Planning Consultation Memo

Date	Planning Officer	Environmental Health Officer
19/01/2022	Ms Ashley Ransome	Terry Vincent
Planning Application Number	Worksheet Number	
6/2021/2571/FULL	WK128924

Address: Judges Judge's Hill Northaw Potters Bar EN6 4NL

Application Details: Erection of a single storey building to rear for use as additional dining space for existing restaurant

1 Judges Hill, Northaw, Potters Bar EN6 4NL  
**GROUND FLOOR PLAN & SITE PLAN**

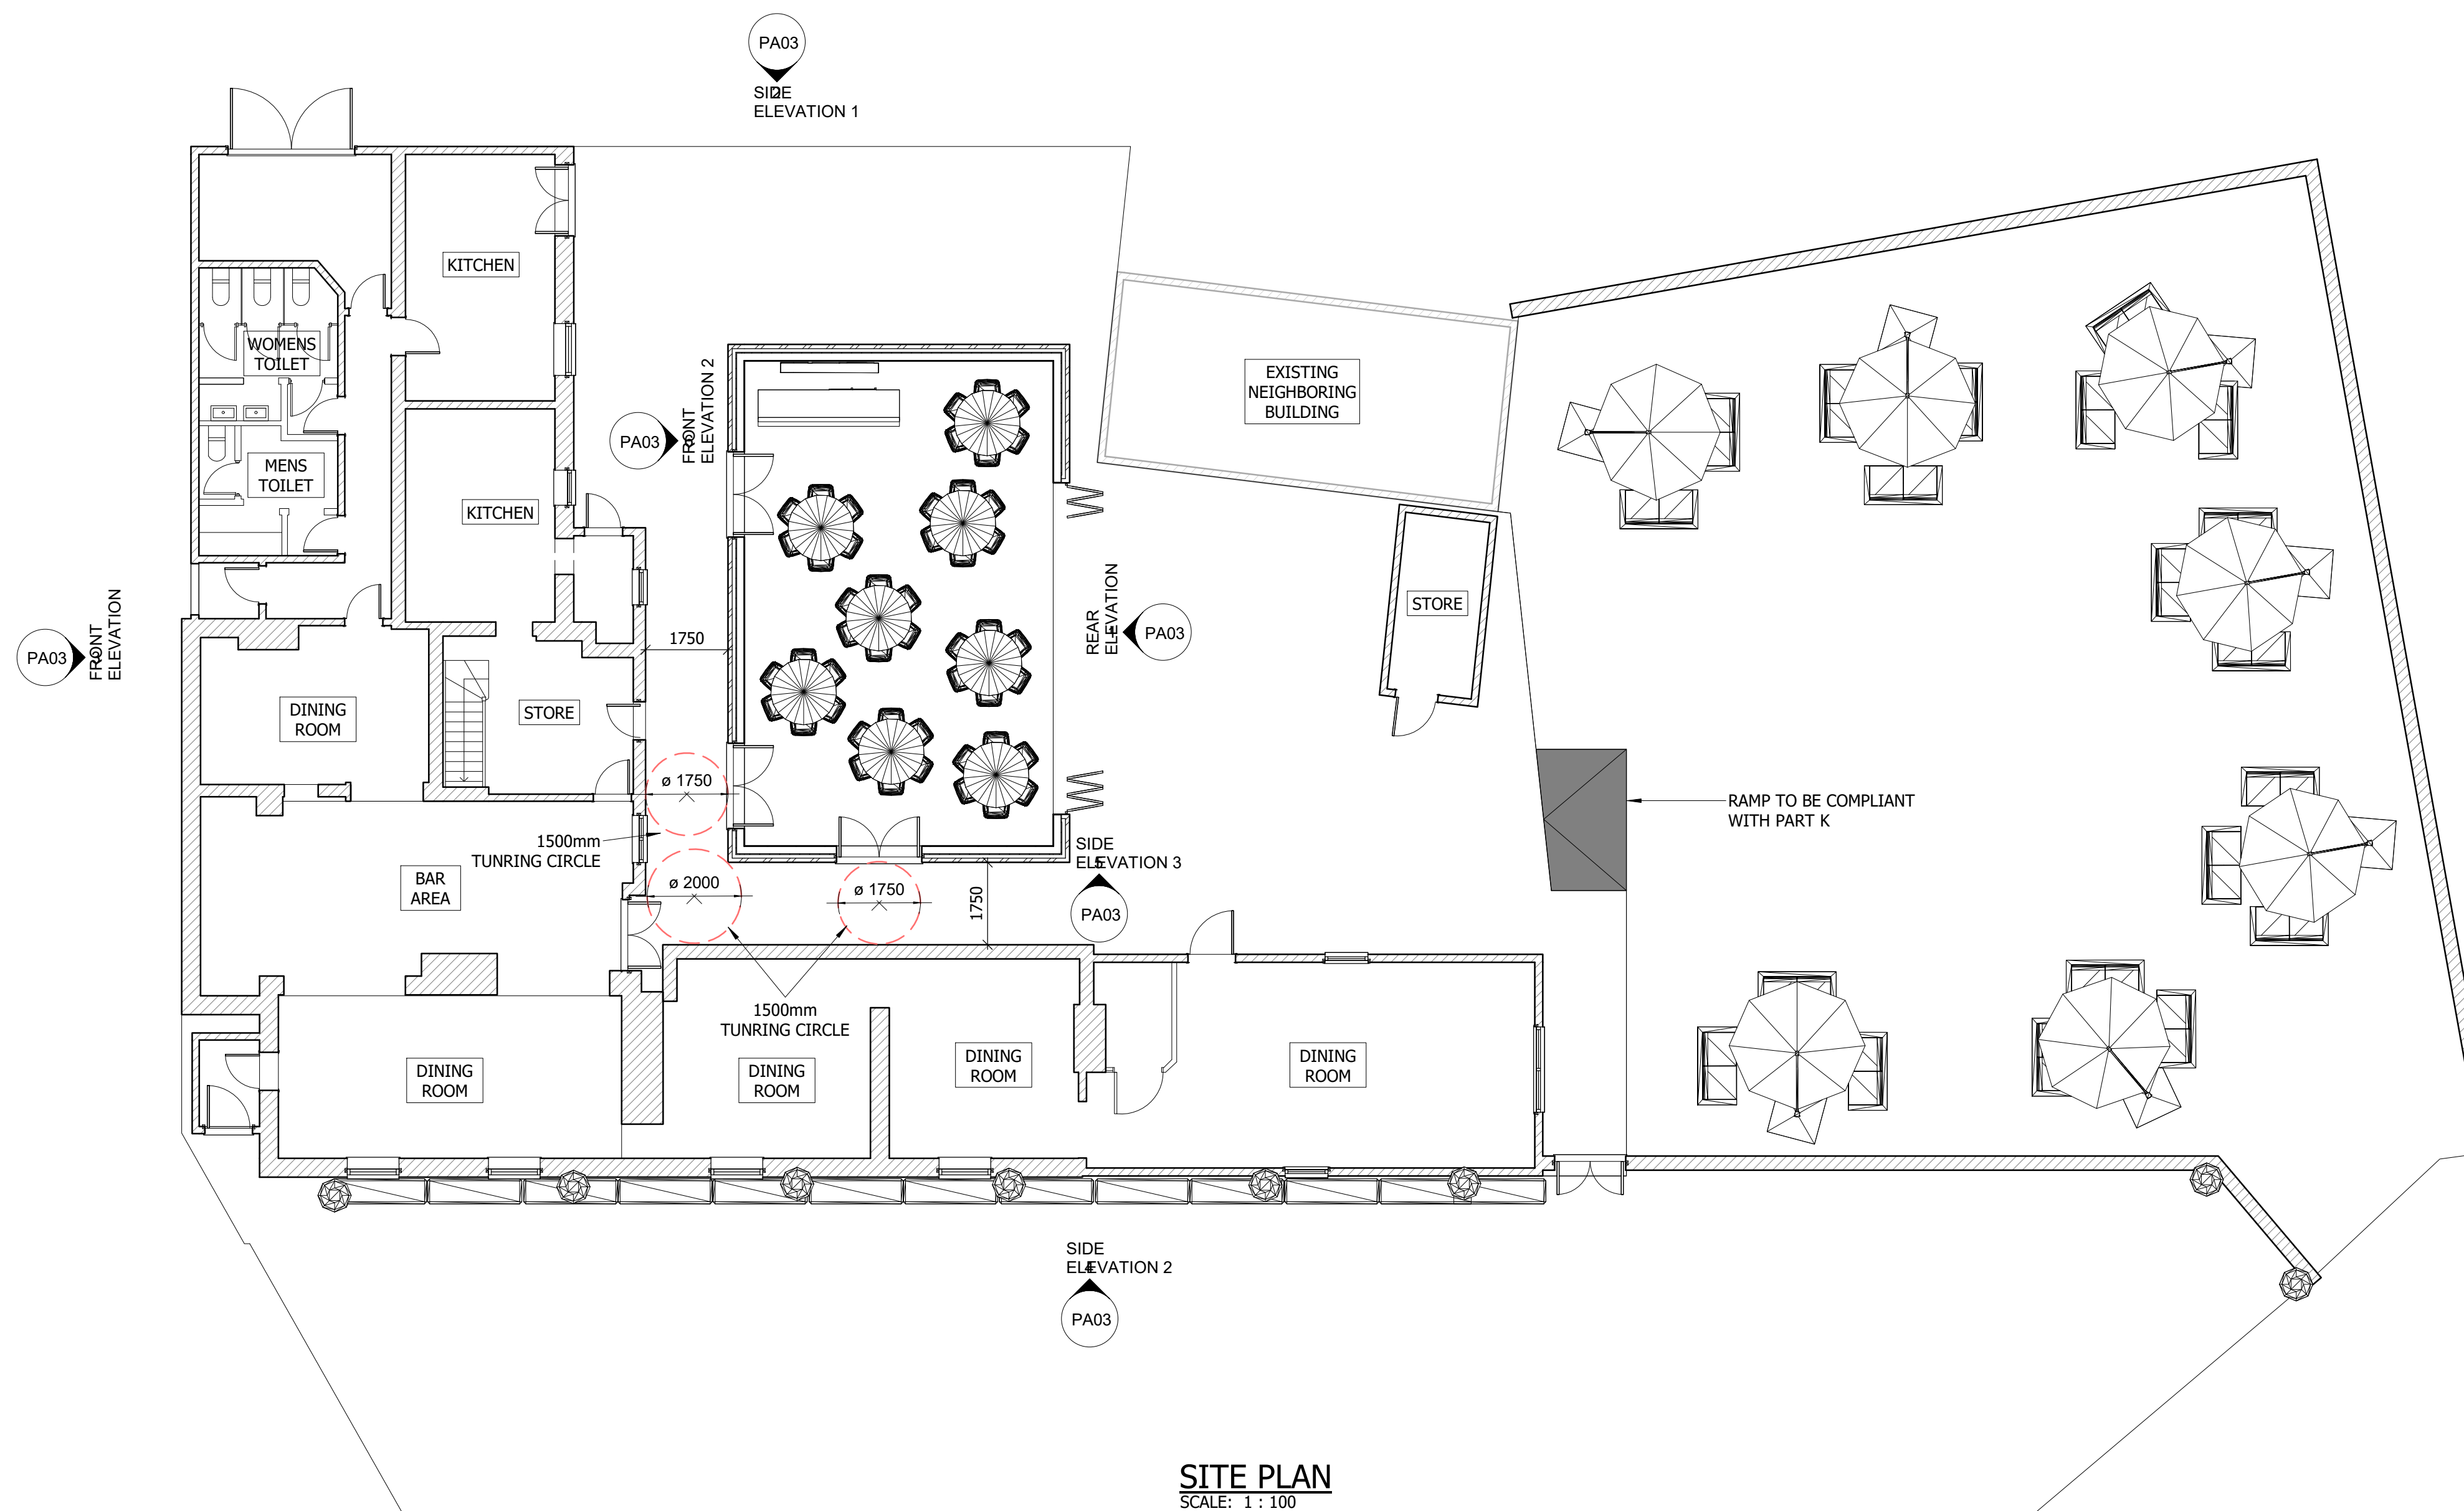
There have been various temporary structures in this location at the rear of the premises for several years. These structures have always been used for a mixture of dining and for the playing of loud amplified music.

If this structure was given planning permission, it would just enable the operators to play loud amplified in this area rather than just within the main building, increasing the risk of a noise nuisance to occurring.

No information has been provided to demonstrate sufficient noise mitigation and to provide the insulation properties of the structure to control noise breakout.

I therefore recommend that the application is refused.
